Charlotte Department of Transportation

Memorandum

Subject: Rezoning Petition 08-152: Located on the southwest corner of Beatties Ford Road and Fairdale Drive
(revised 11/17/08)

04DEC08	NEW SURVEY
17NOV08	ZONING COMMENTS
PROJECT	0812
DATE	21APR08
DRAWN BY	PML
CHECKED BY	CEL
SITE PLAN	
A1

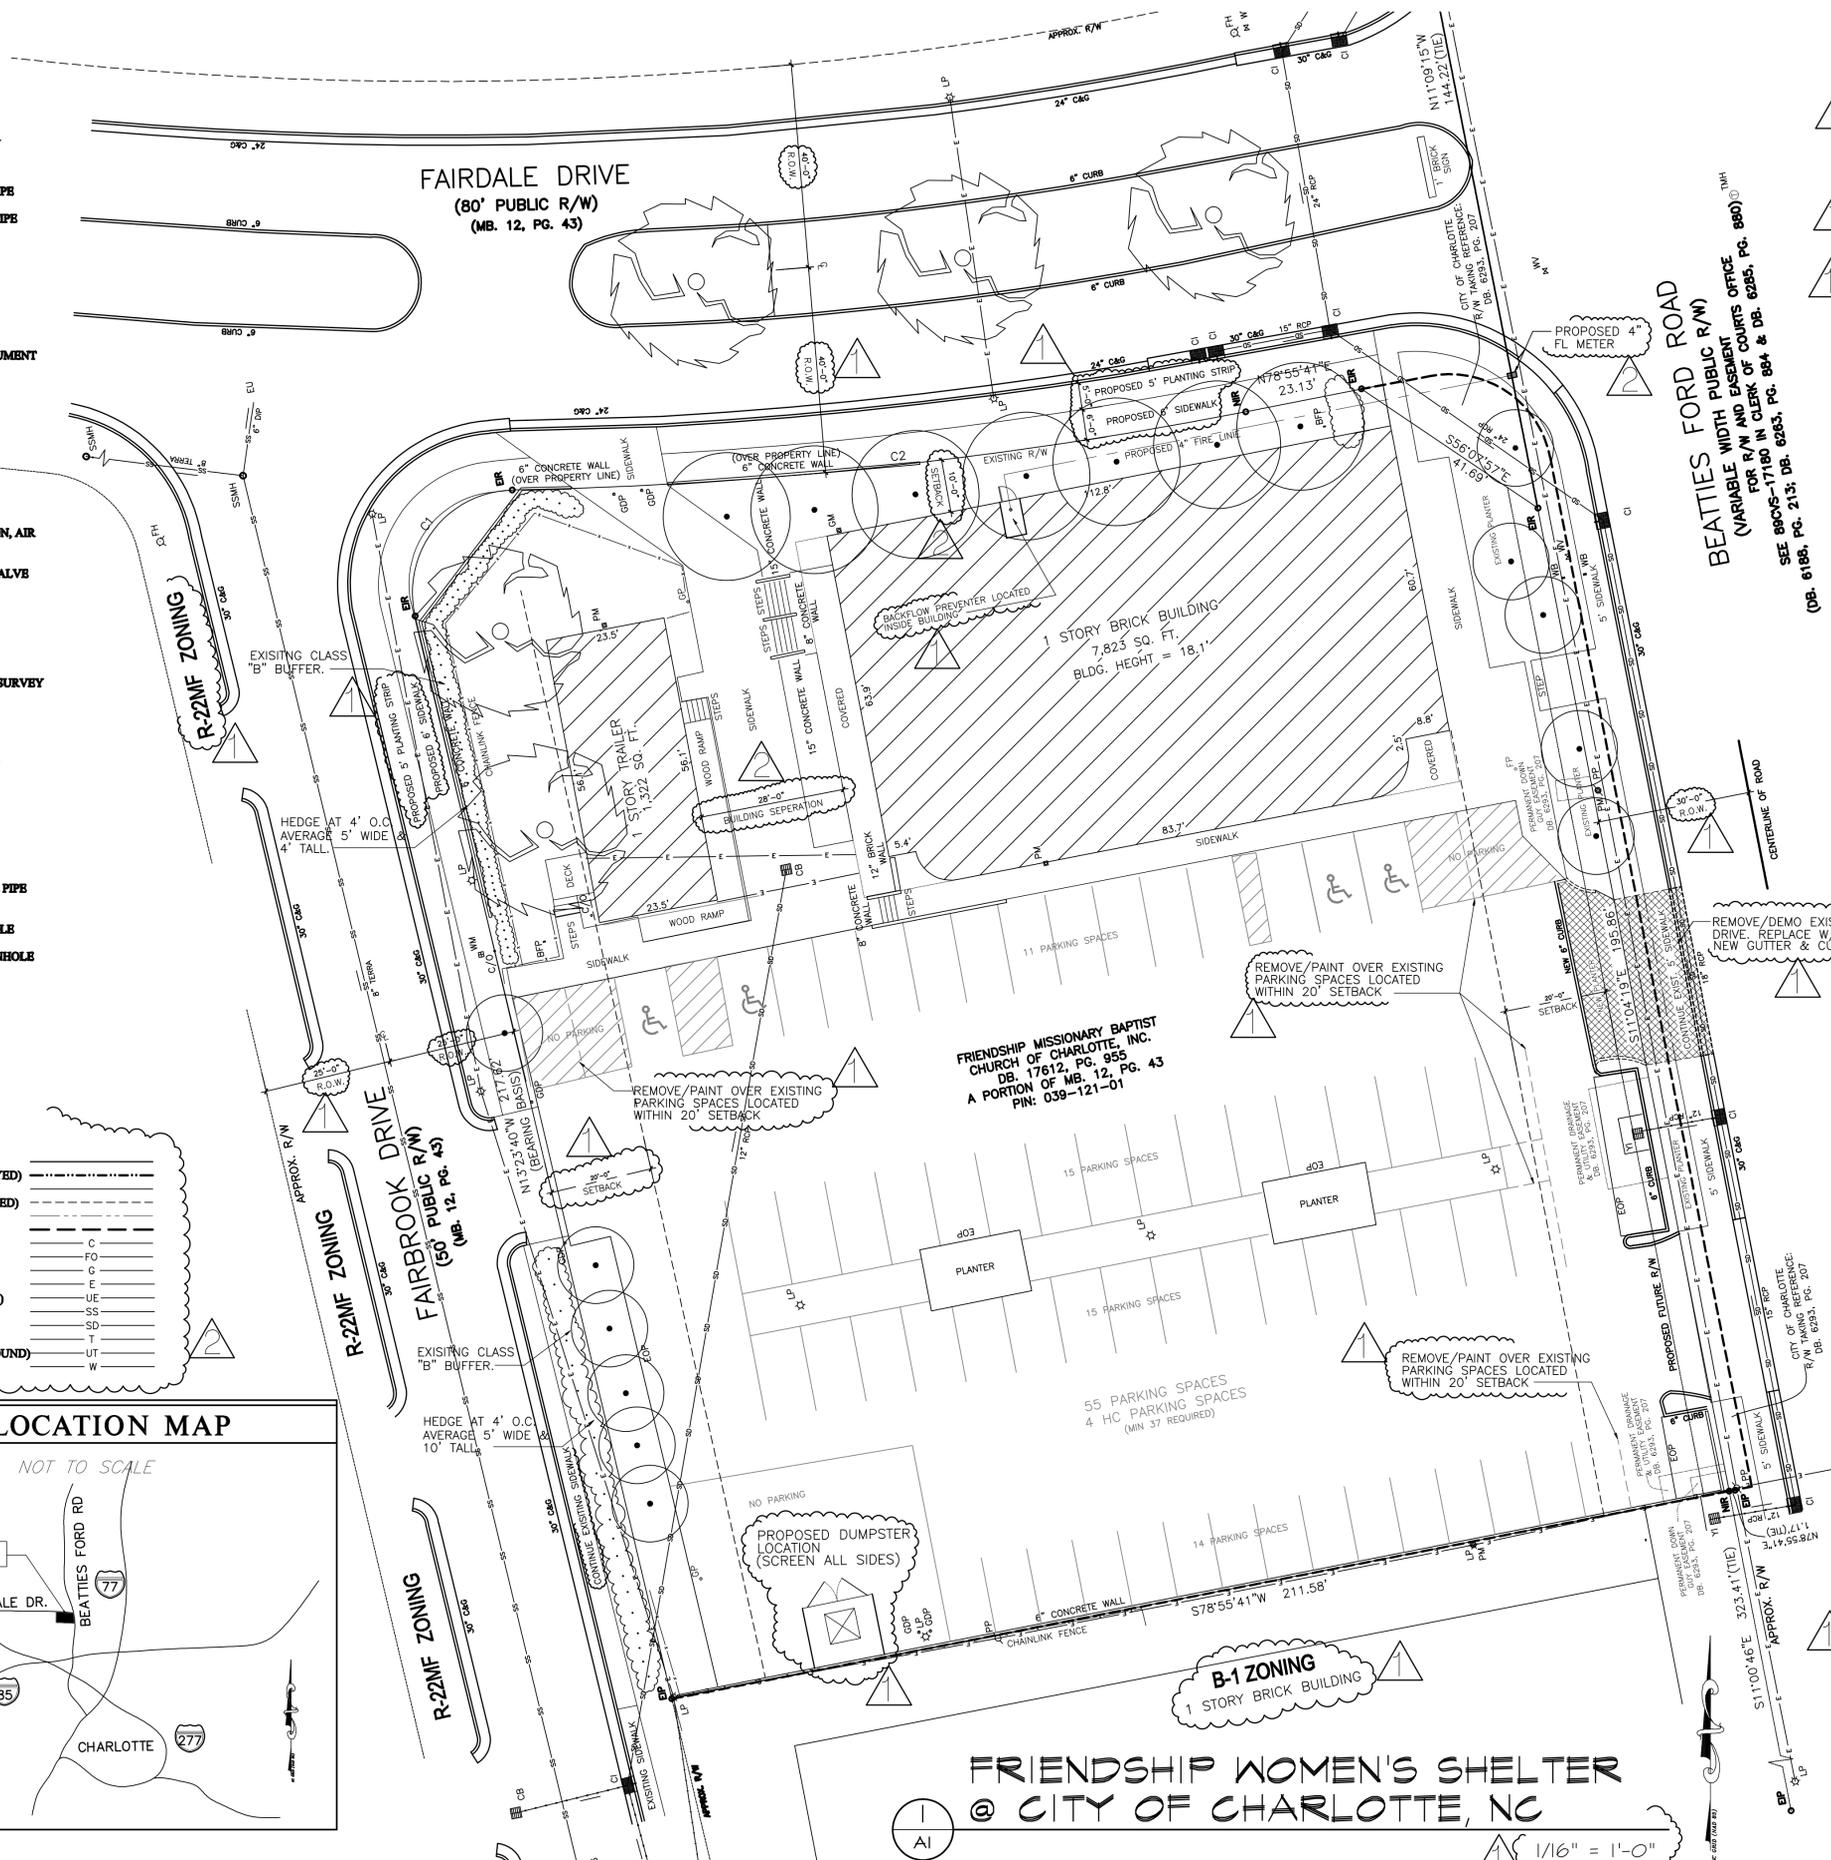
1. Drive/parking circulation aisles are not permitted in the setback as shown on the site plan. These drive aisles need to be removed and the site plan revised accordingly. (*Previous review comment*)
2. The developer needs to replace the existing sidewalks at the back-of-curb along Beatties Ford Road with 12-foot planting strips and 6-foot sidewalks. (*Previous review comment*)

3. Bus parking was shown in the southwest corner of the parking lot on the previous site plan. The current site plan shows a dumpster in this location. The function of this area needs to be clarified and if bus parking is to be accommodated, where it will be located.
4. The Access Points note needs to be revised to include only one access to Beatties Ford Road and one to Fairbrook Drive.
